Addendum No. 1

RE: Contract # C204202

WBS # 15BPR.20

I-26/US-74 WEST BOUND LANES AND EAST BOUND LANES OVER
GREEN RIVER.

**AT BENTS 1 & 4 EXPANSION JOINTS**

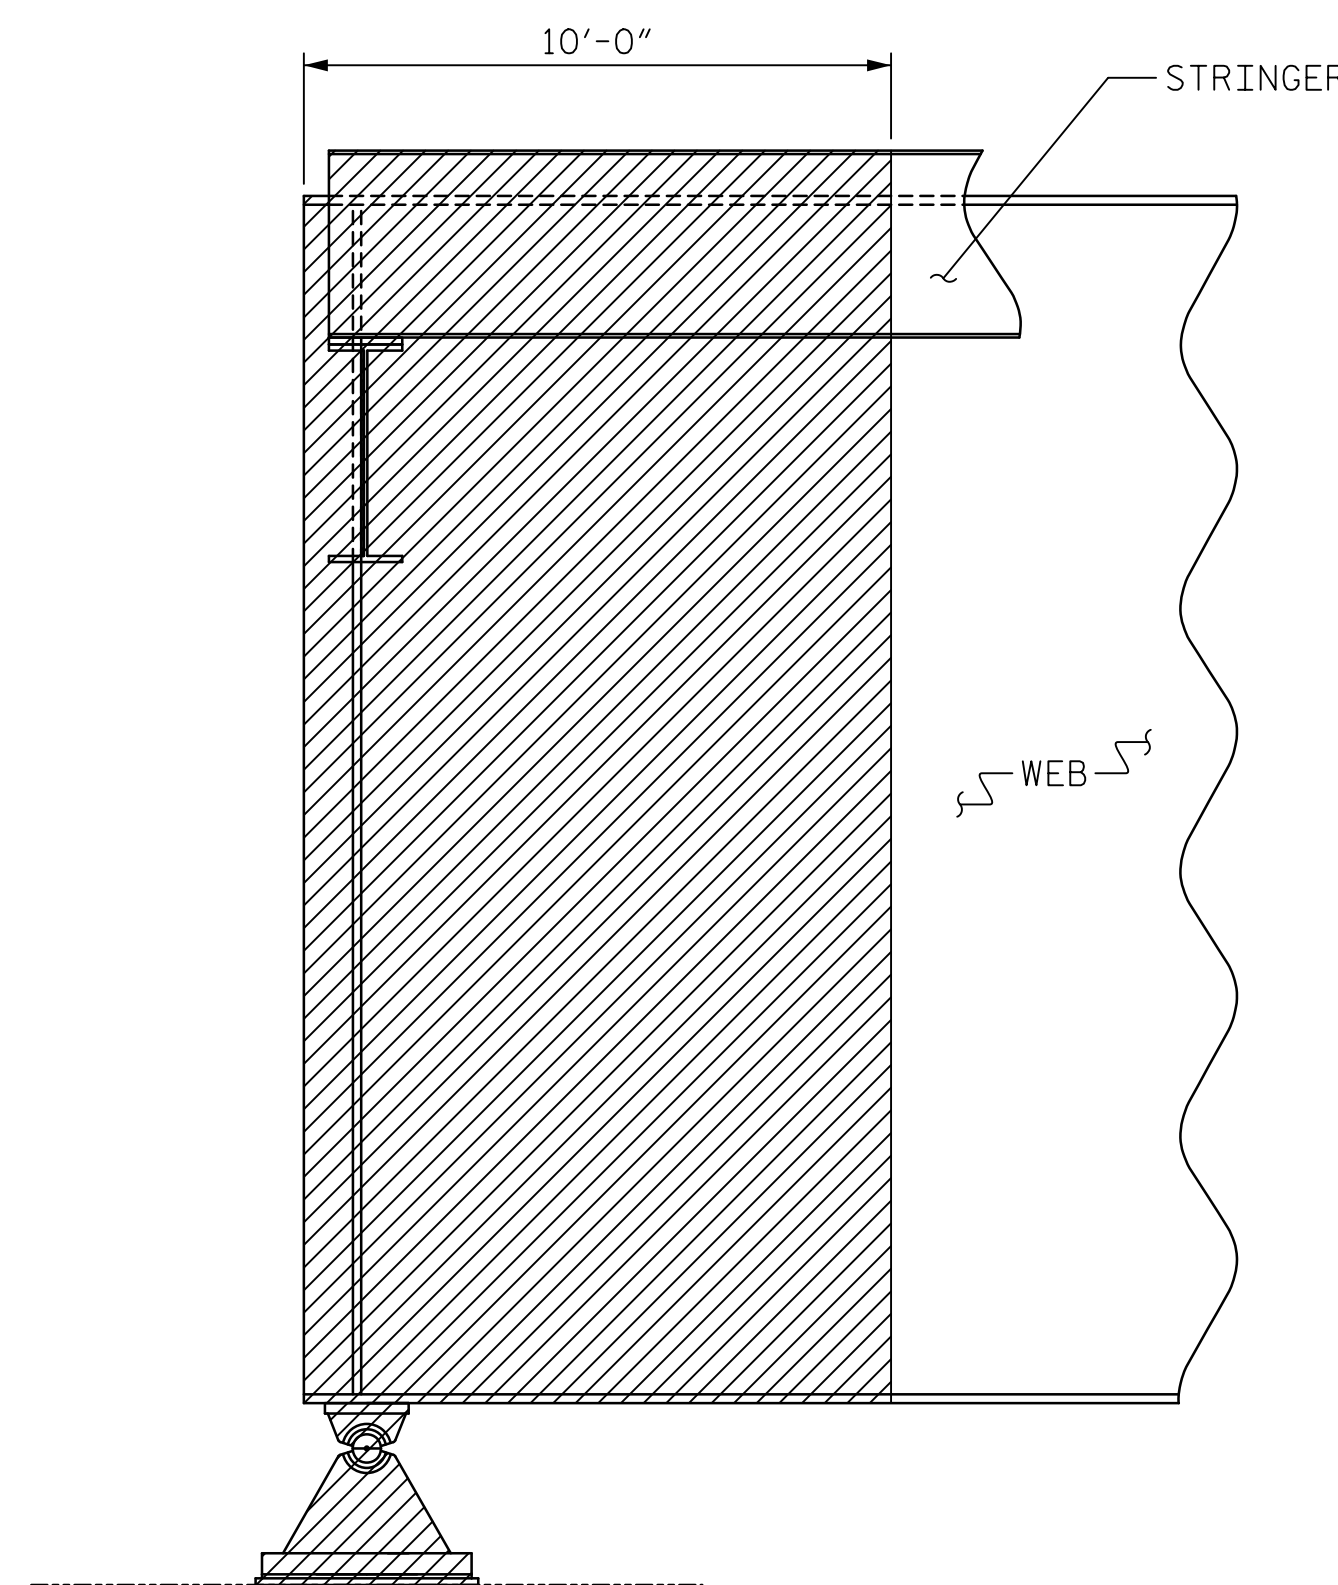
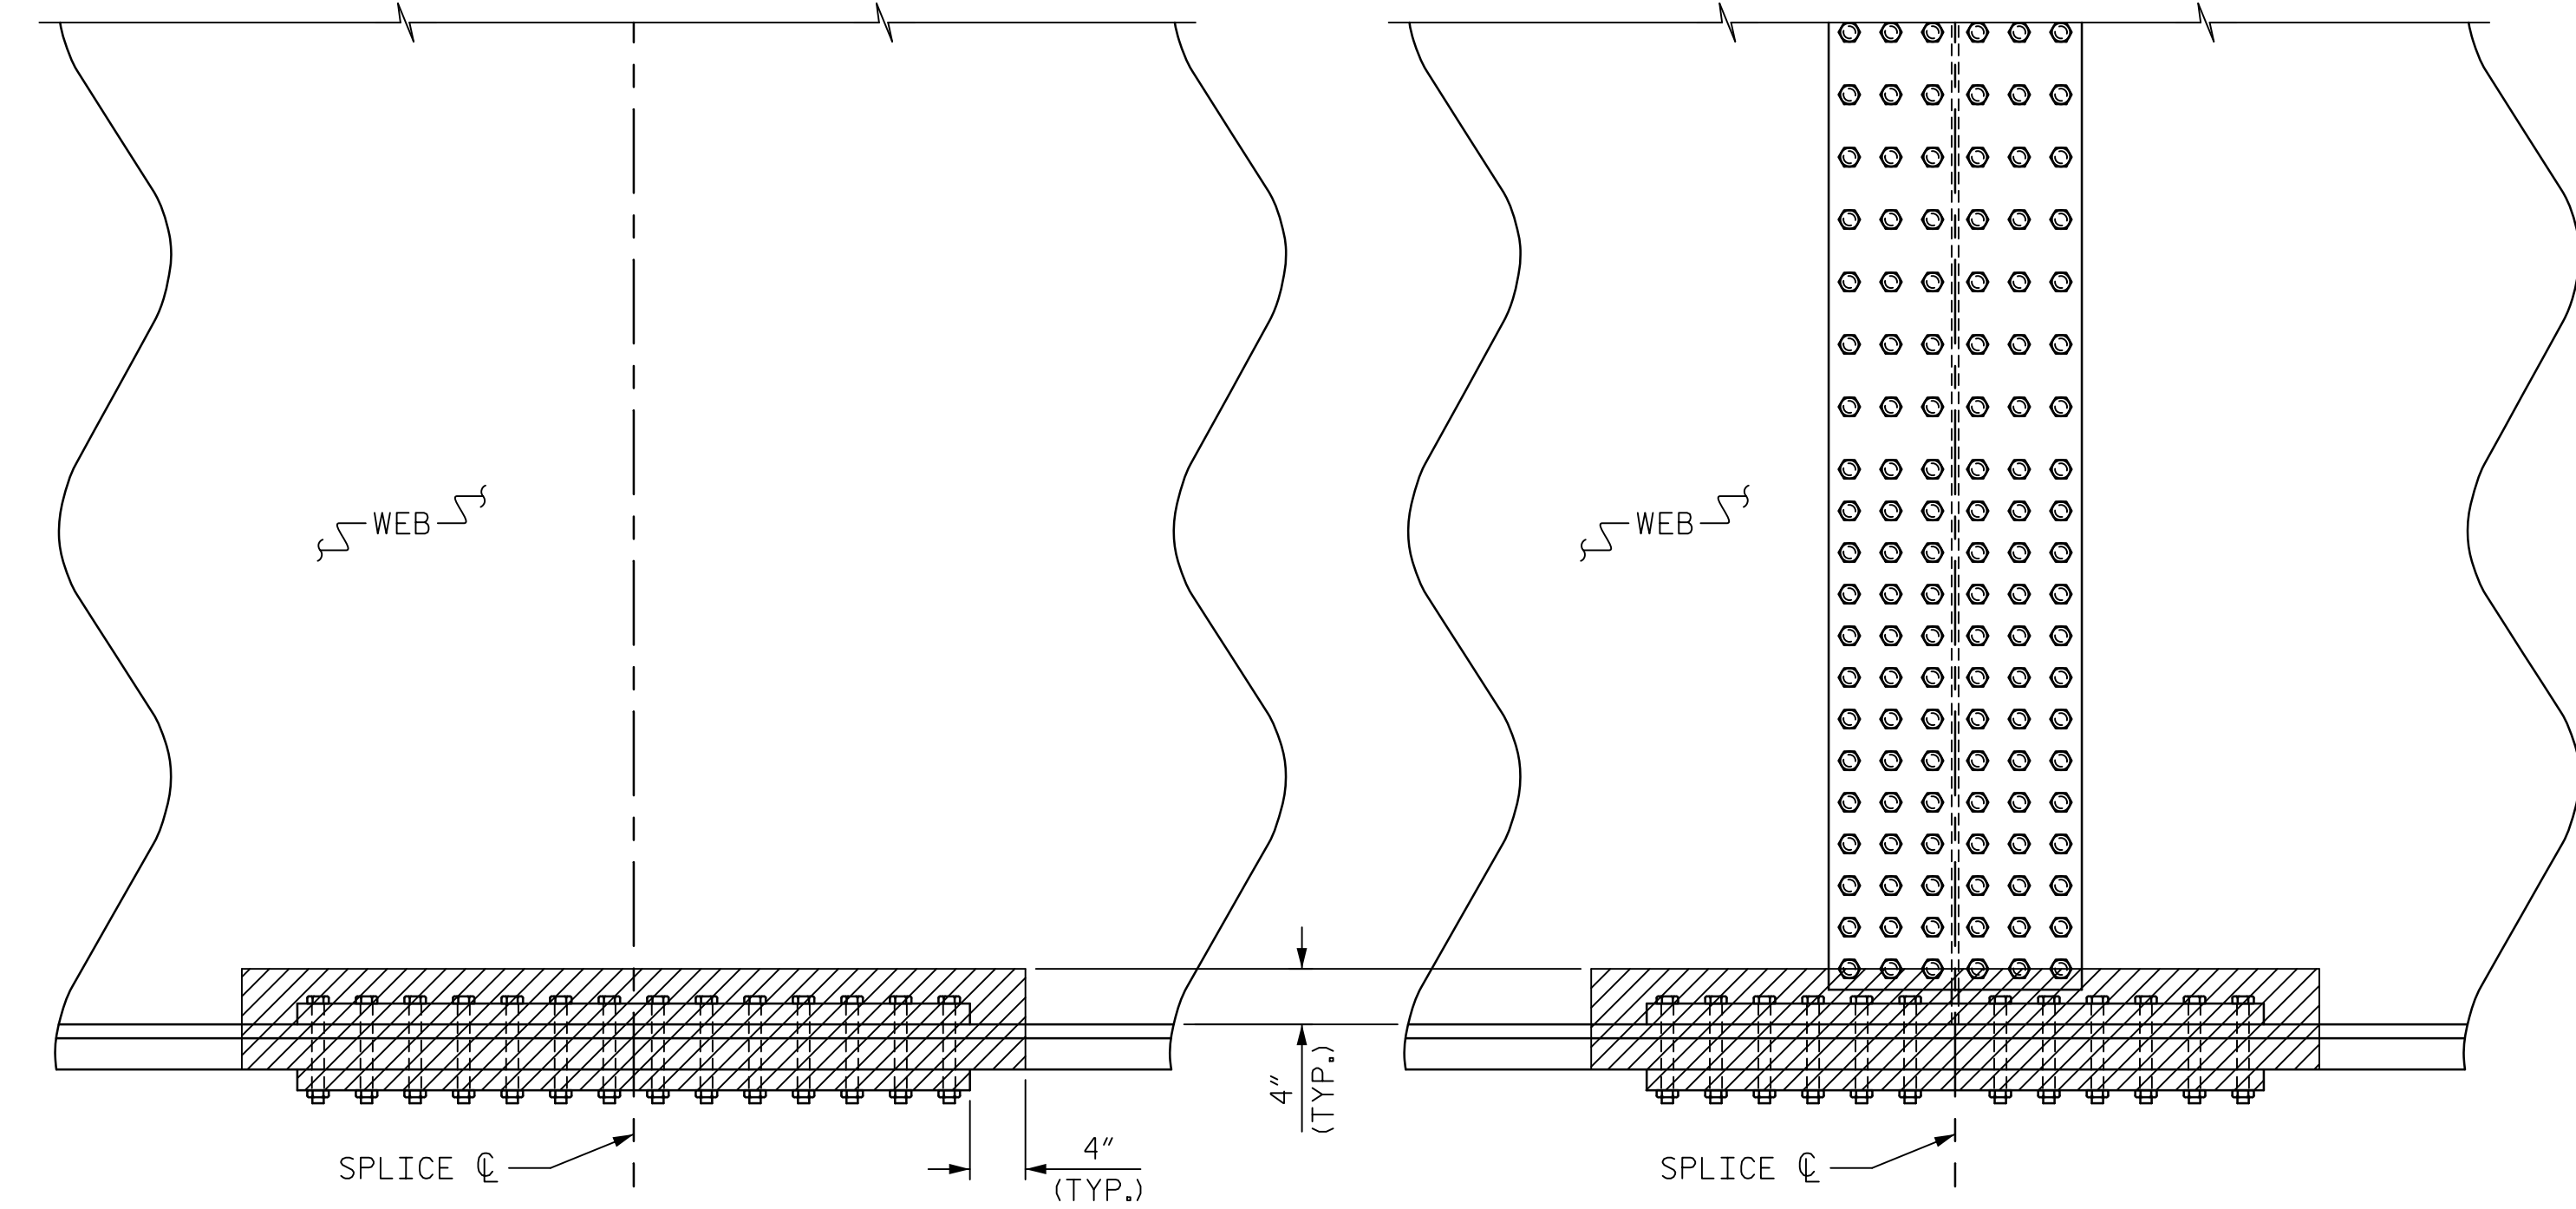
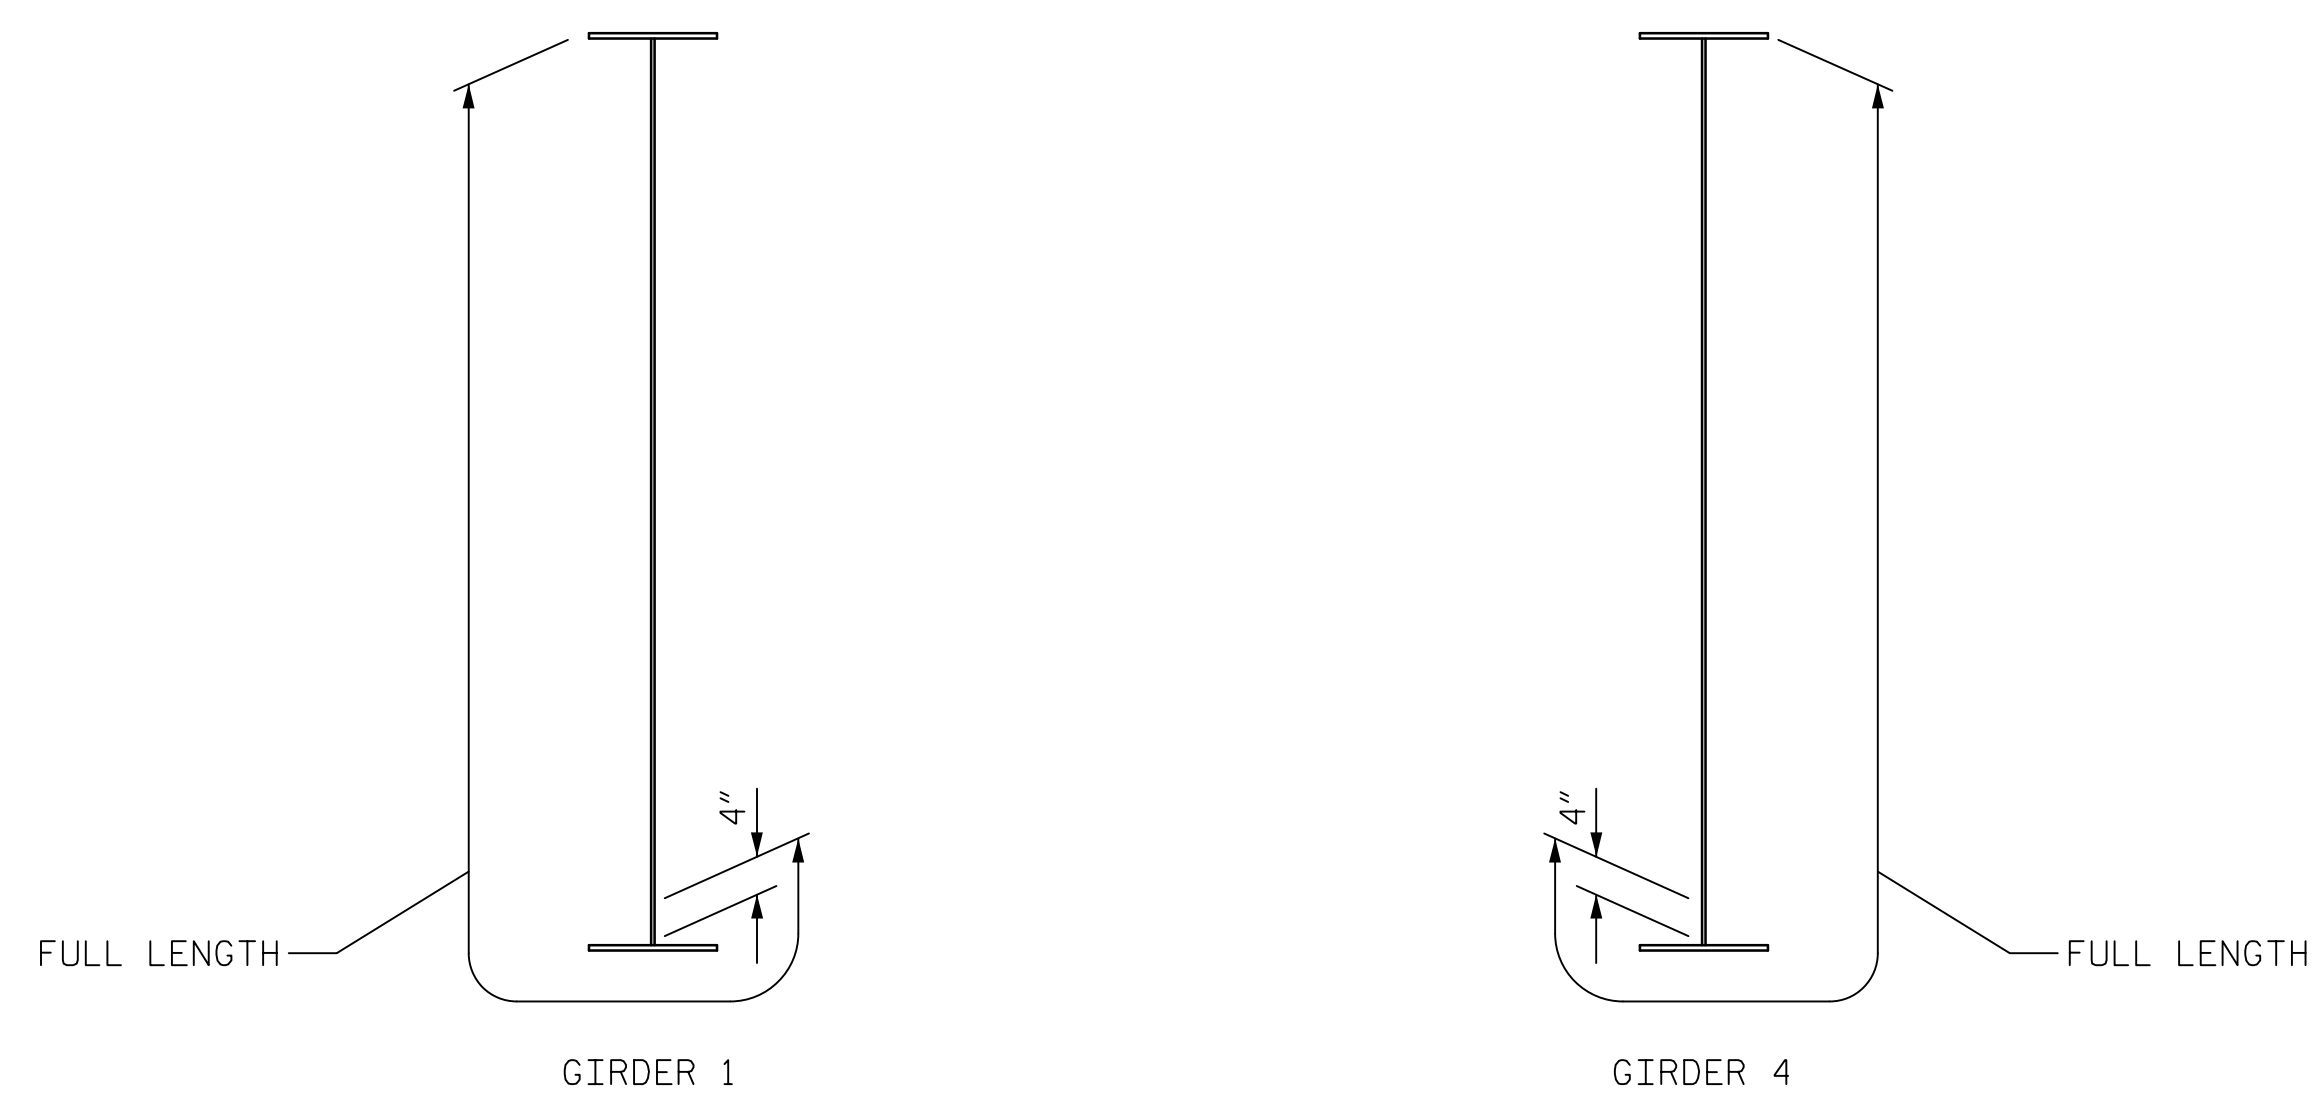
Sheet No.	Revision
S-7	Updated weld repair W4 quantities to a pay unit of each and a quantity of 5. Added quantities for bridge washing with a pay unit of each and a quantity of 30.
S-11	Added pay item for bridge washing with a unit of Each and a quantity of 30. Updated 3 notes: 1. demolition and construction work with pay item information, 2. the note about bridge washing, and 3. the note about removing utilities.
S-82	Added locations to weld repair W4
S-85	Added locations to weld repair W4
S-94	Changed weld repair W4 pay unit from lump sum to Each with a quantity of 5.
S-95	Deleted dashed line around girder 4 backstation bearing at bent 4.
S-96	Deleted the first note on the sheet referring to replacement of anchor bolts.
